Planning Application Ref: AW/259/18/PL

Location: 10 Barrack Lane, Aldwick, PO21 4BZ

Description of works: 1 No. dwelling

Comments on Application:

10 Barrack Lane, Bognor Regis - 'No Dig' Construction Typical Section

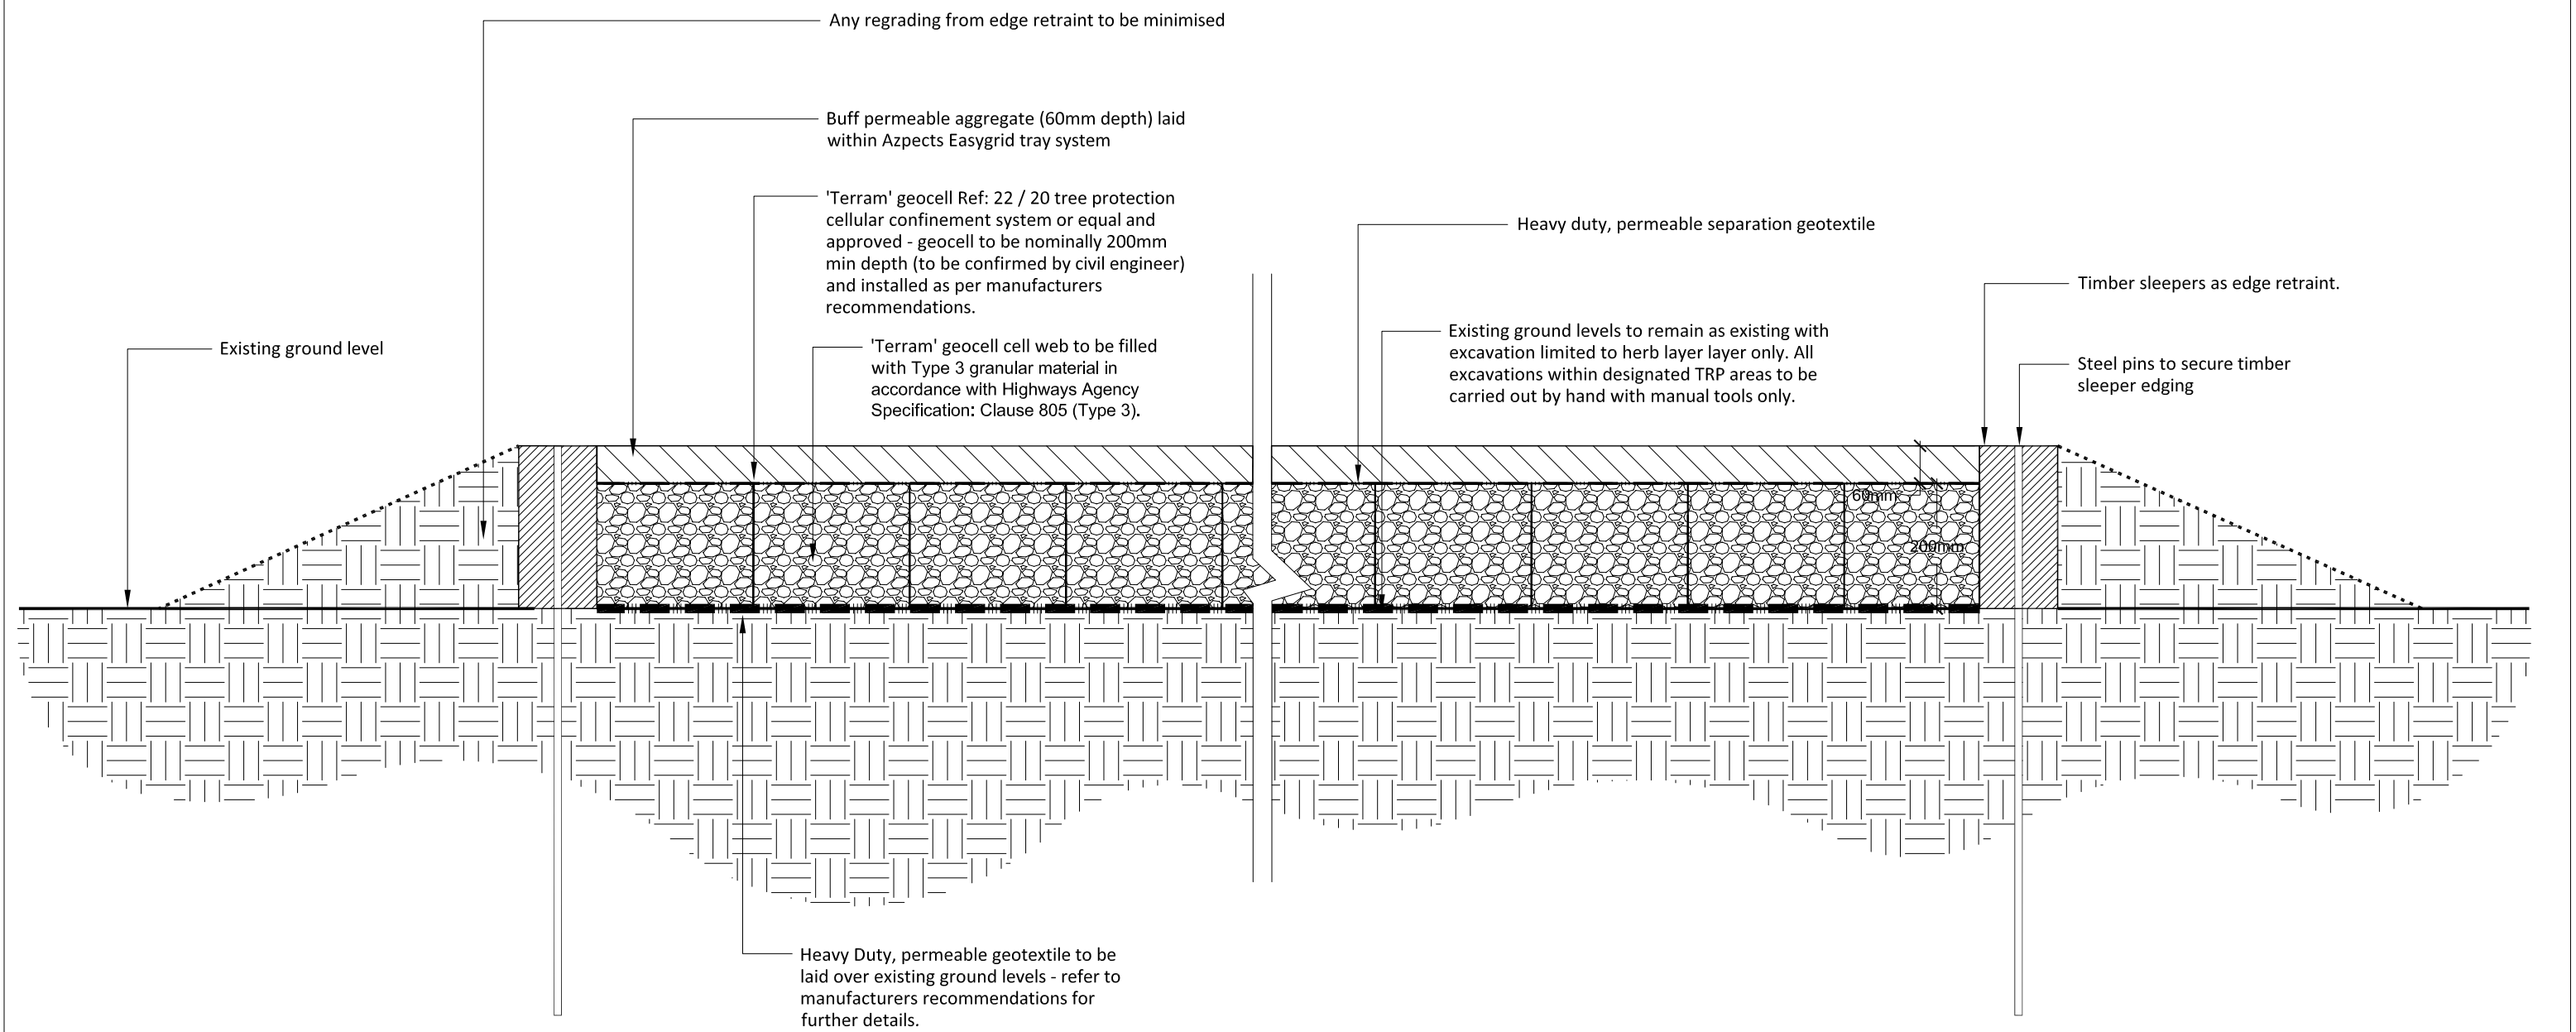
2. There is not enough detail in the specification for the *No-dig solution*, which is especially important in this instance as it is proposed to be in place prior to any demolition/construction and must therefore have load bearing capability sufficient to support construction traffic. I have not seen any detail in relation to materials/timing of installation for the hard wearing surface, which must be permeable. [Although only a typical representation and not specified exactly, the example No-dig construction, ref.RCo241/03 incorporating a 200mm cellular confinement system ought to be adequate. It also provides detail of a permeable hard wearing surface. The timing of installation had in fact already been set out in Chapter 4.0 of the AIA, para.4.1.2, which confirms the No-dig driveway will be installed prior to commencement of demolition and construction activities on the site.](#)

- I would like written confirmation from the engineer providing the cellular confinement system (*No-dig solution*) that it will have sufficient load bearing capability to endure the entire phase of development and retain sufficient integrity so as to accept a permeable hard wearing surface (as yet unspecified). [Not provided but further detail has been submitted in the form of a typical representation of construction drawing and which will form part of the following conditions.](#)

- The No-dig construction must be as described and shown in the drawing **No Dig Construction: Typical Section, dwg.no. RCo241/03, Rev.01, dated 22-01-19.** Any significant deviation from this specification, especially with regard to the depth and manufacturer of the cellular confinement system must be submitted for prior approval by this authority.
